A1 Birtley to Coal House

Scheme Number: TR010031

Summary of Proposed Changes to Application January 2020

**The A1 Birtley to Coal House
Development Consent Order 20[xx]**

KINGSWAY VIADUCT (JUNCTION 67)
PROPOSED CROSS SECTION B-B
SCALE 1:50

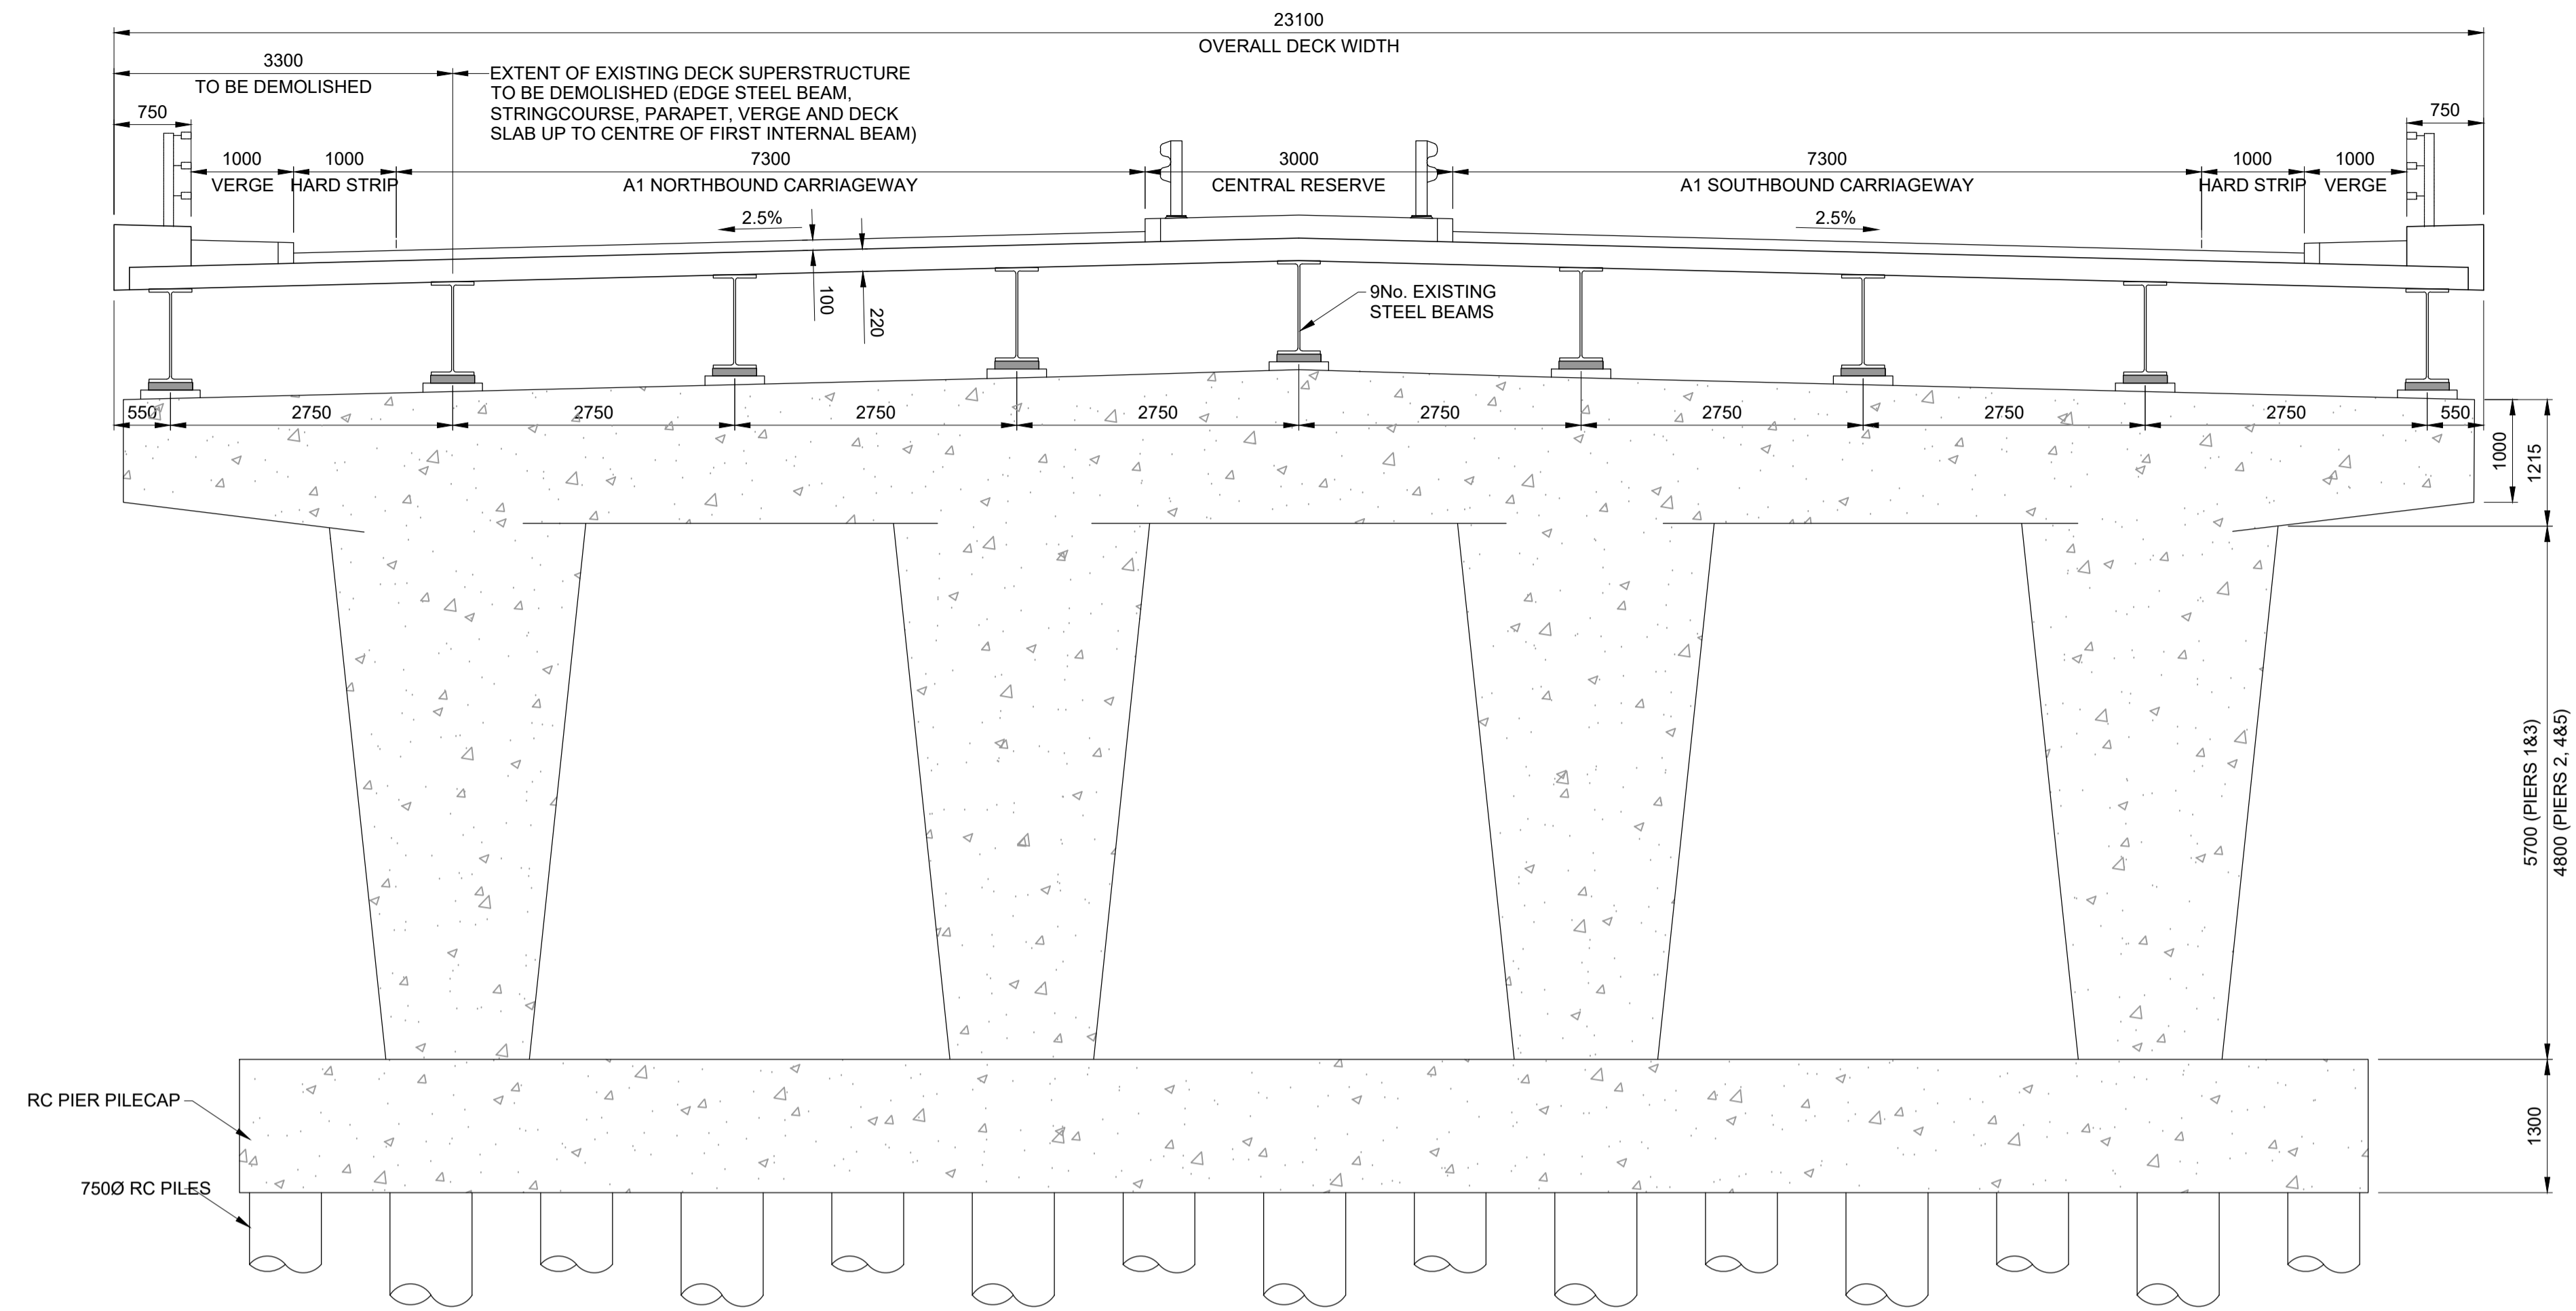
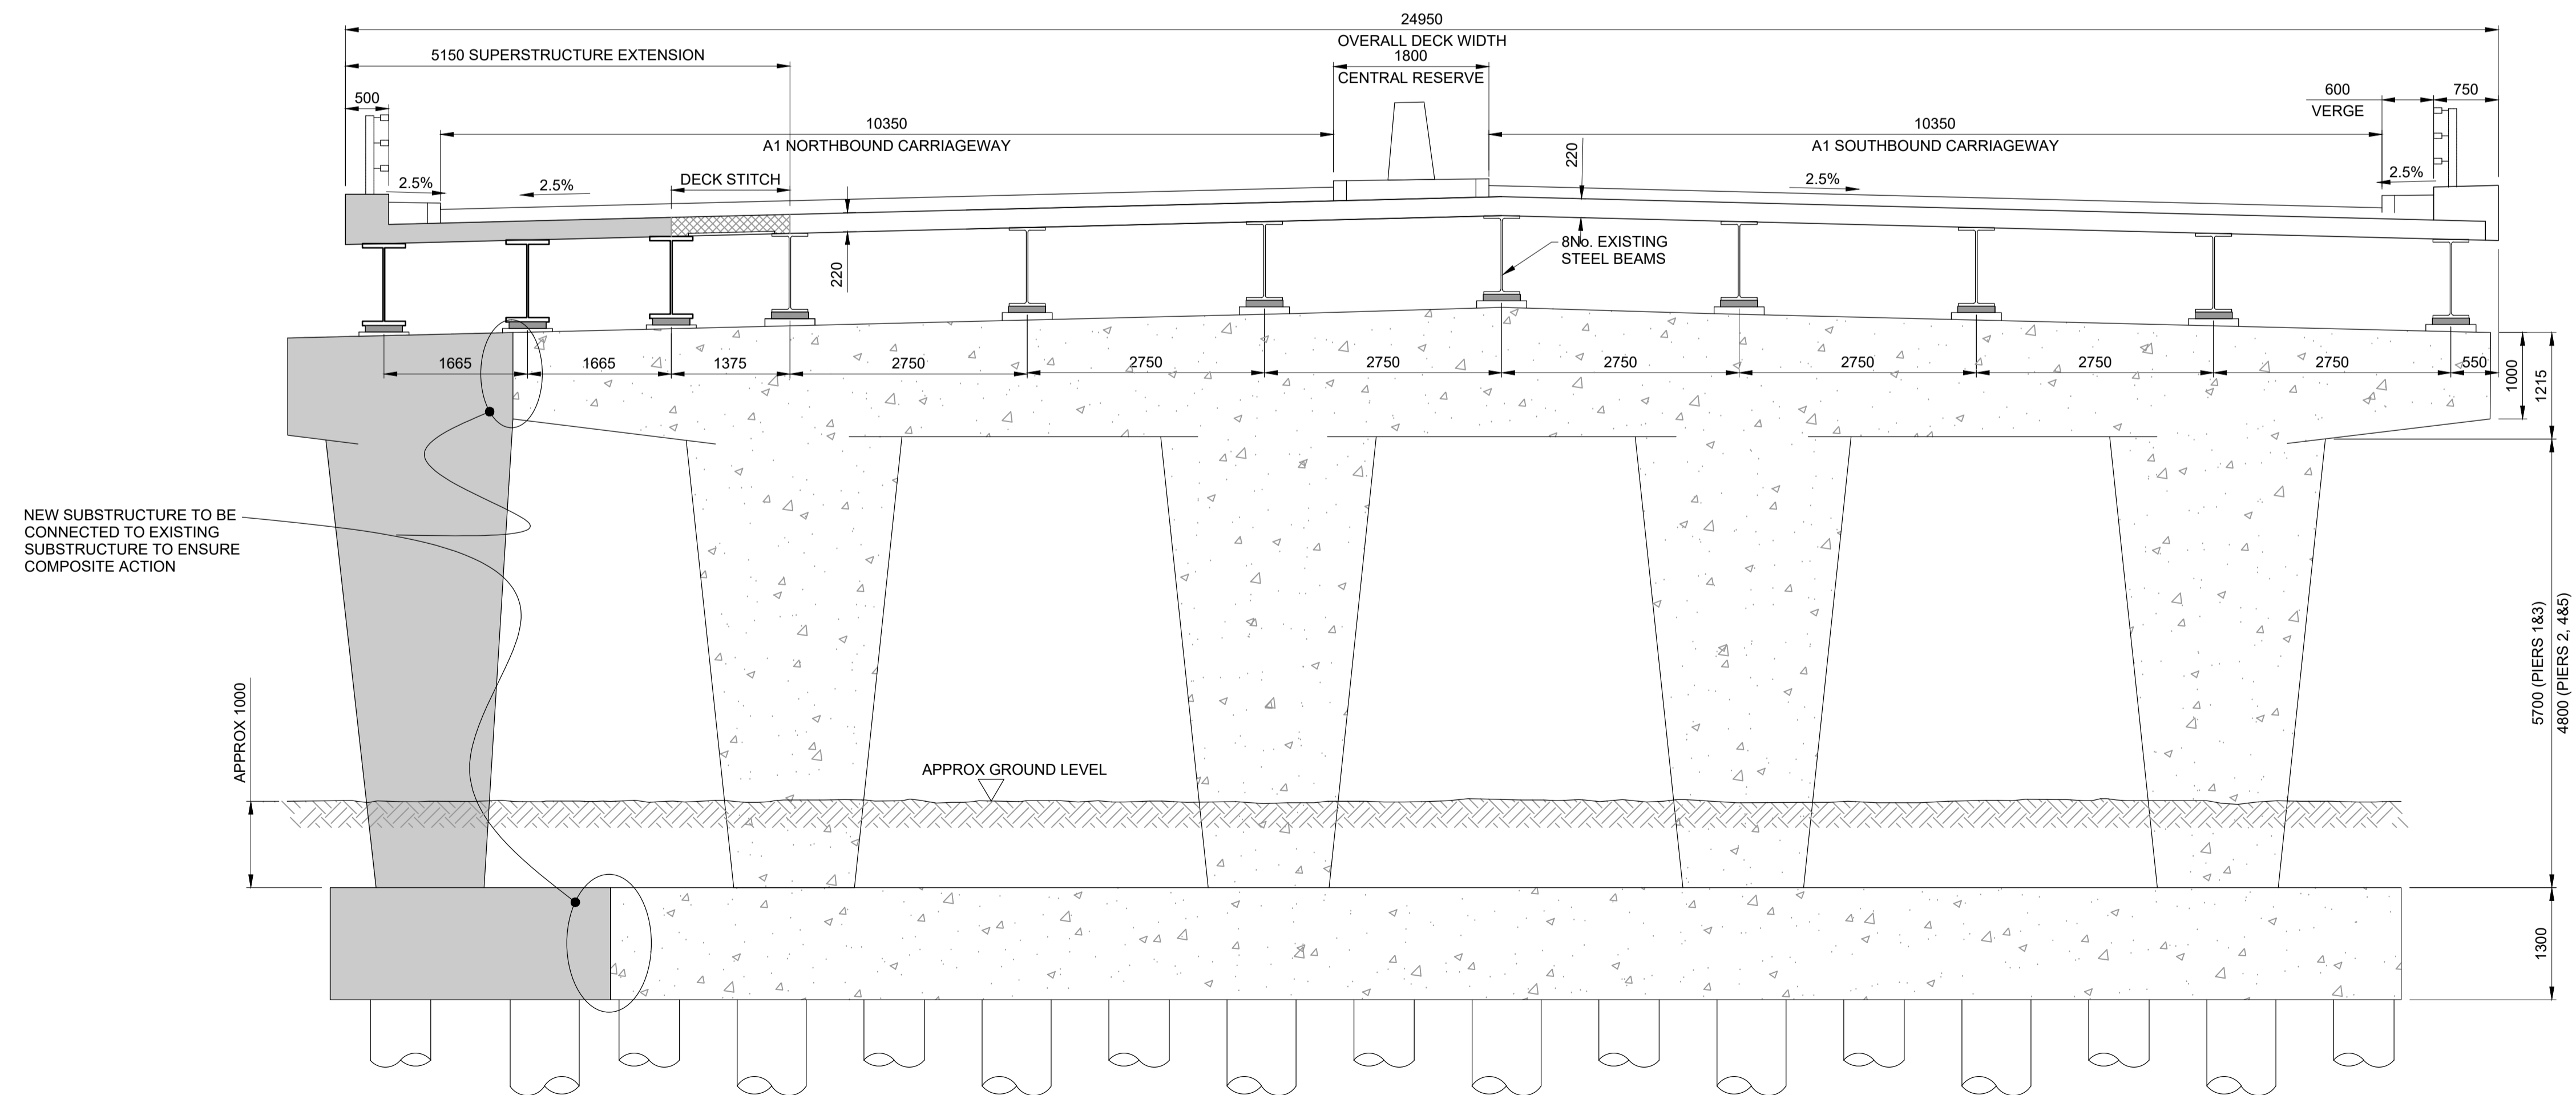
2. Providing flexibility as to the formation and the road layout of the Scheme to enable narrower lanes to be provided between the existing narrow lanes north of junction 67 and approximately chainage 11150 over Kingsway Viaduct at junction 67. The current scheme proposes full width lanes. The new proposal is to allow narrower lanes extending over approximately 750m of the length of the Scheme to be introduced.

2.1.15 The Application currently provides powers to provide full width lanes through the entire length of the Scheme within the DCO. To the north of junction 67, the recently implemented A1 Coal House to Metro Scheme already provides narrower lanes, and the transition from narrower lanes to full width lanes is currently expected to take place to the north of junction 67. The Applicant is now proposing to amend the Application to allow provision for narrower lanes to be extended by up to 750m southwards through the Scheme at junction 67 and over Kingsway Viaduct. The transition between full width lanes and narrower lanes would then commence immediately south of Kingsway Viaduct at approximately chainage 11150.

Design Scenario	Description	Southbound Carriageway					C/R	Northbound Carriageway				Widening required to Kingsway Viaduct
		Verge	Lane 1	Lane 2	Lane 3	Lane 3		Lane 2	Lane 1	Verge		
A	DMRB compliant standard	2m	3.65 m	3.7 m	3.65 m	1.8 m	3.65 m	3.7 m	3.65 m	2m	6m	
B	Current Application	2.5m	3.65 m	3.7 m	3.65 m	1.8 m	3.65 m	3.7 m	3.65 m	2.5m	7m	
C	Proposed Option	0.6m	3.65 m	3.5 m	3.2m	1.8 m	3.2m	3.5 m	3.65 m	0.6m	2.1m

2.1.17 The proposed narrow lane option would reduce the width of the cross-sectional components, which is a common approach taken to modern highway improvement schemes in order to maximise the use of existing infrastructure assets such as bridge structures. However, this will require a departure from standards from the DMRB through detailed design, so exact details of the cross-sectional dimensions and therefore the extents of any necessary widening to the structure cannot be fully determined at this stage. However, the cross-section configuration shown

- 2.1.19 Applying this constrained cross section would reduce the structural widening at Kingsway Viaduct by approximately 5m (2.1m compared to 7m in the DCO application design). The benefits of this are examined further below.

**ALLERDENE BRIDGE (3 SPAN OPTION)
PLAN**
SCALE 1:1000

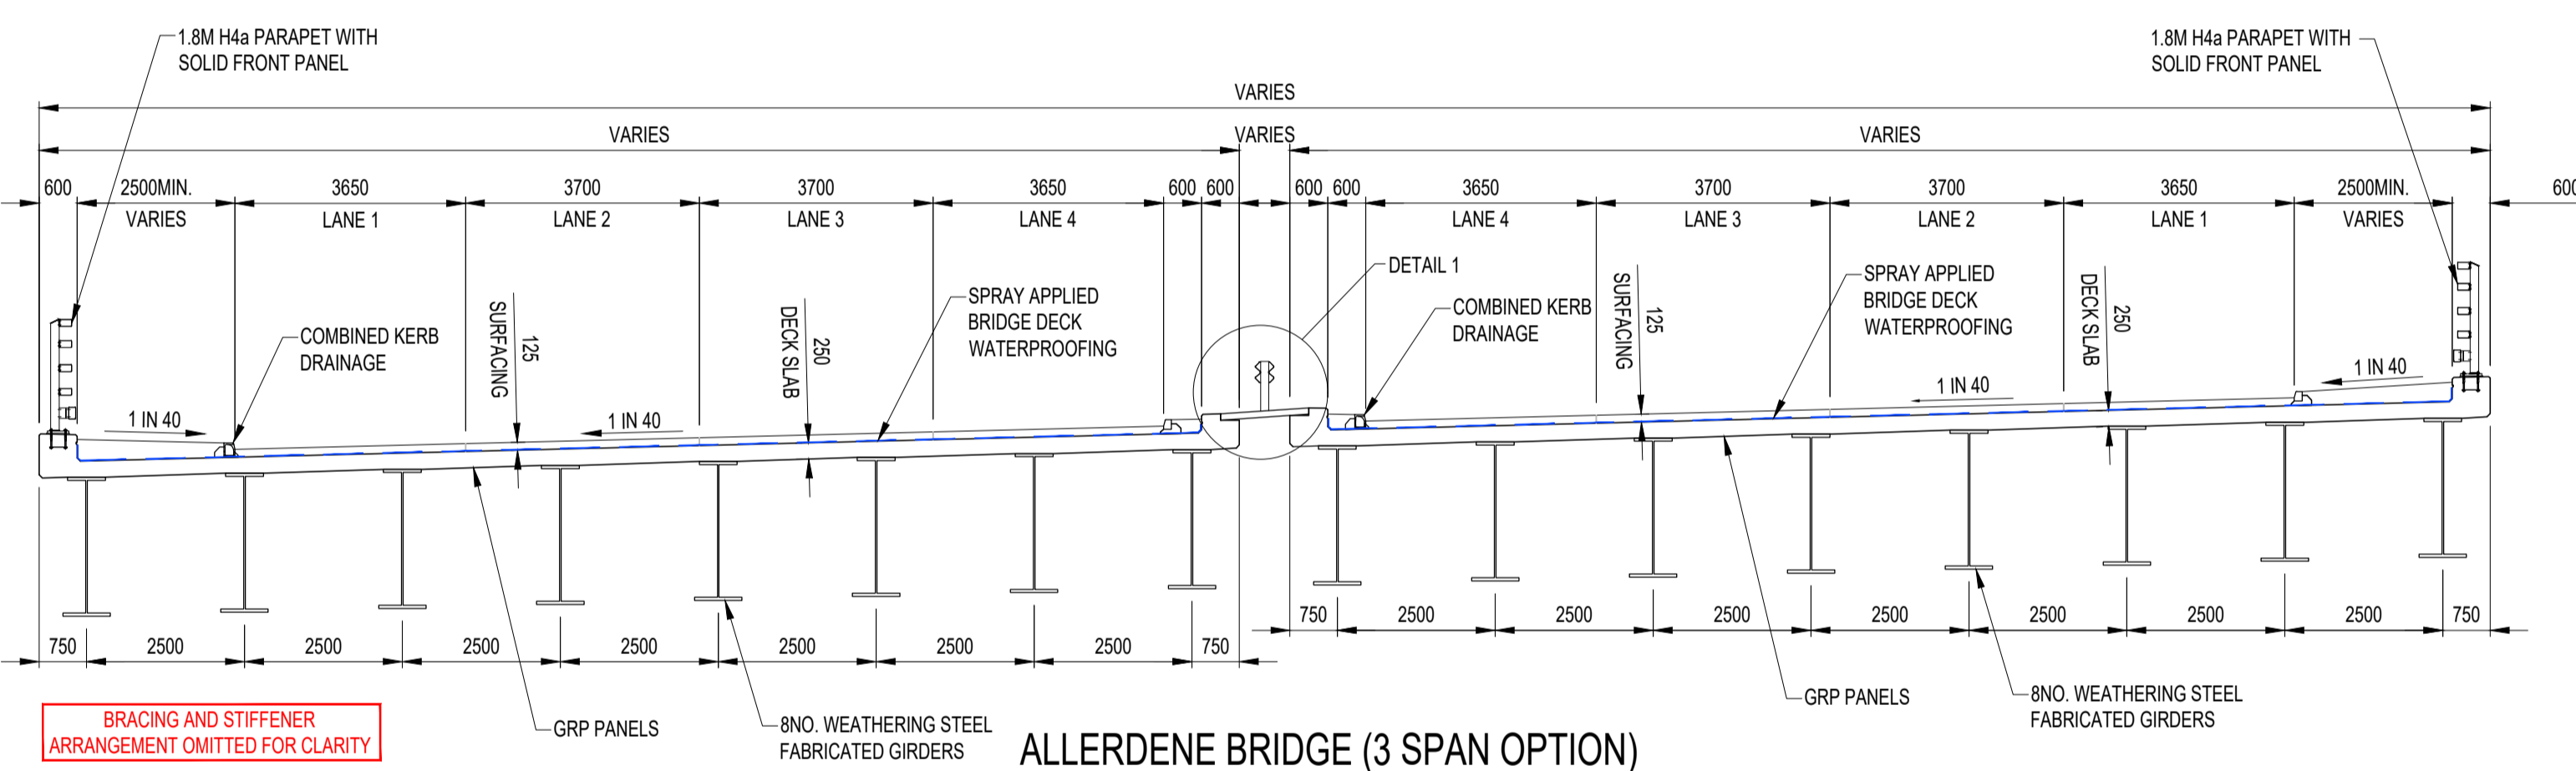
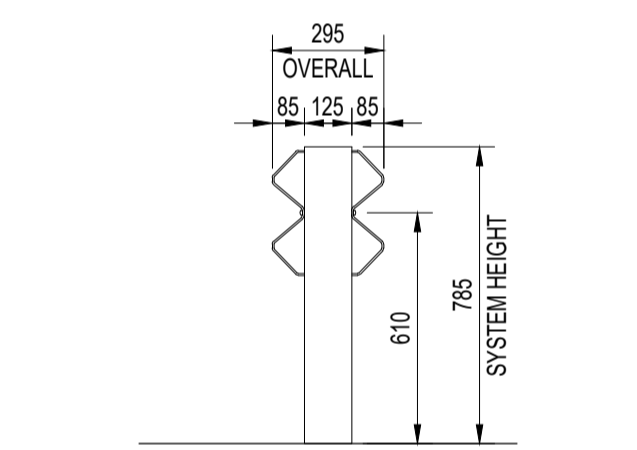
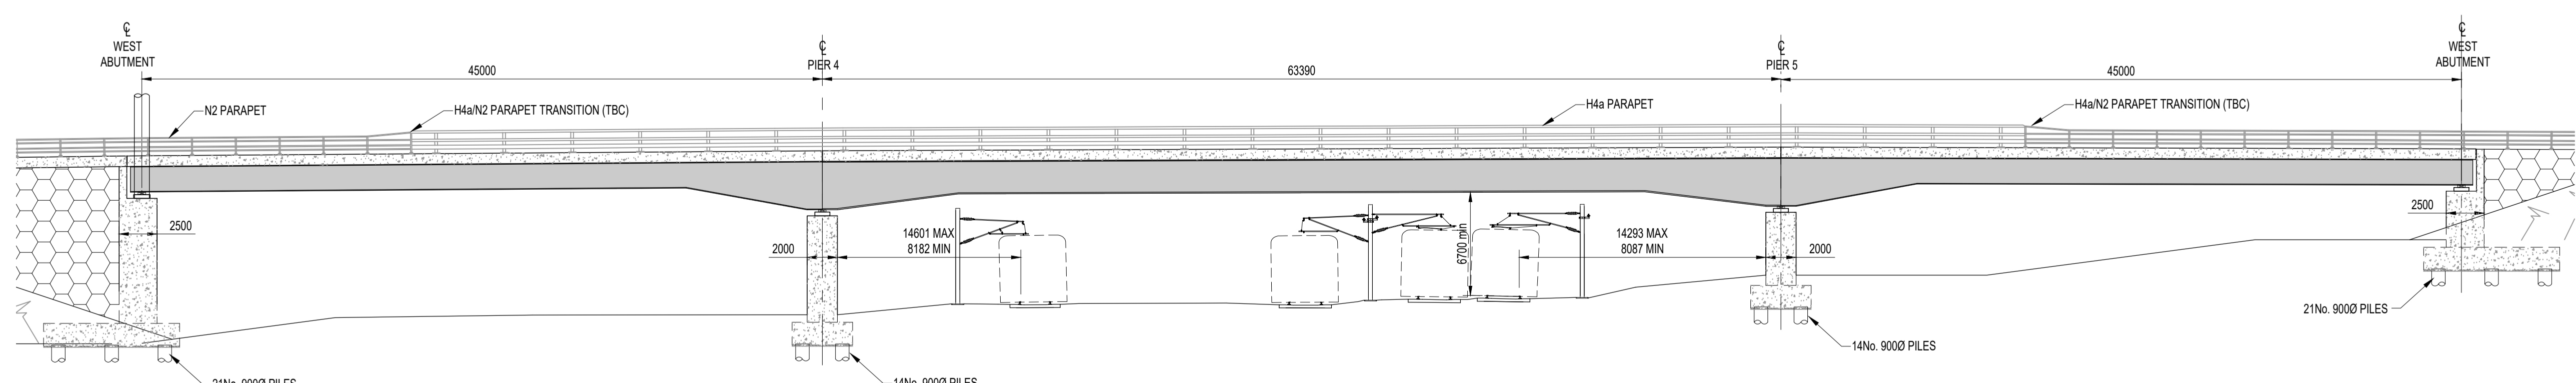
- 2.1.1 The Applicant proposes to amend the Application to enable a 3-span viaduct with reinforced embankments to be constructed to provide the new alignment for the A1 over the East Coast Main Line and replacement for Allerdene Railway Bridge. It is proposed that this option should be provided for within the Application in addition to the single span integral bridge and 6/7 span viaduct that are currently provided for within the DCO and other application documents.

- 2.1.2 The 3-span viaduct proposal would comprise a central span (of approx. 65m in length), which would pass over the railway, with back spans to the east and west of the railway (each approx. 45m in length). The form of the superstructure would be a composite deck comprising a reinforced concrete deck slab atop steel girders as for the other options. This form is unchanged from the DCO application design.

- 2.1.3 It is also proposed that reinforced soil is used to form the approach embankments to the east and west of the railway. This would result in slopes being steepened to a suggested maximum angle of 60 degrees (from the current 1 (vertical) in 3 (horizontal) slope within the DCO application).

2.1.9 The alignment of the proposed structure will be unchanged. The footprint would change so as to reflect the division between embankment and bridge/viaduct, and the embankment would also be altered as a result of the steepening of its slopes as described at paragraph 2.1.3 above. The culvert which carries Allerdene Burn will appear as shown on Sheet 3 of the Structures Engineering Drawings and Sections (**Application Document Reference. TR010031/APP/2.7**)
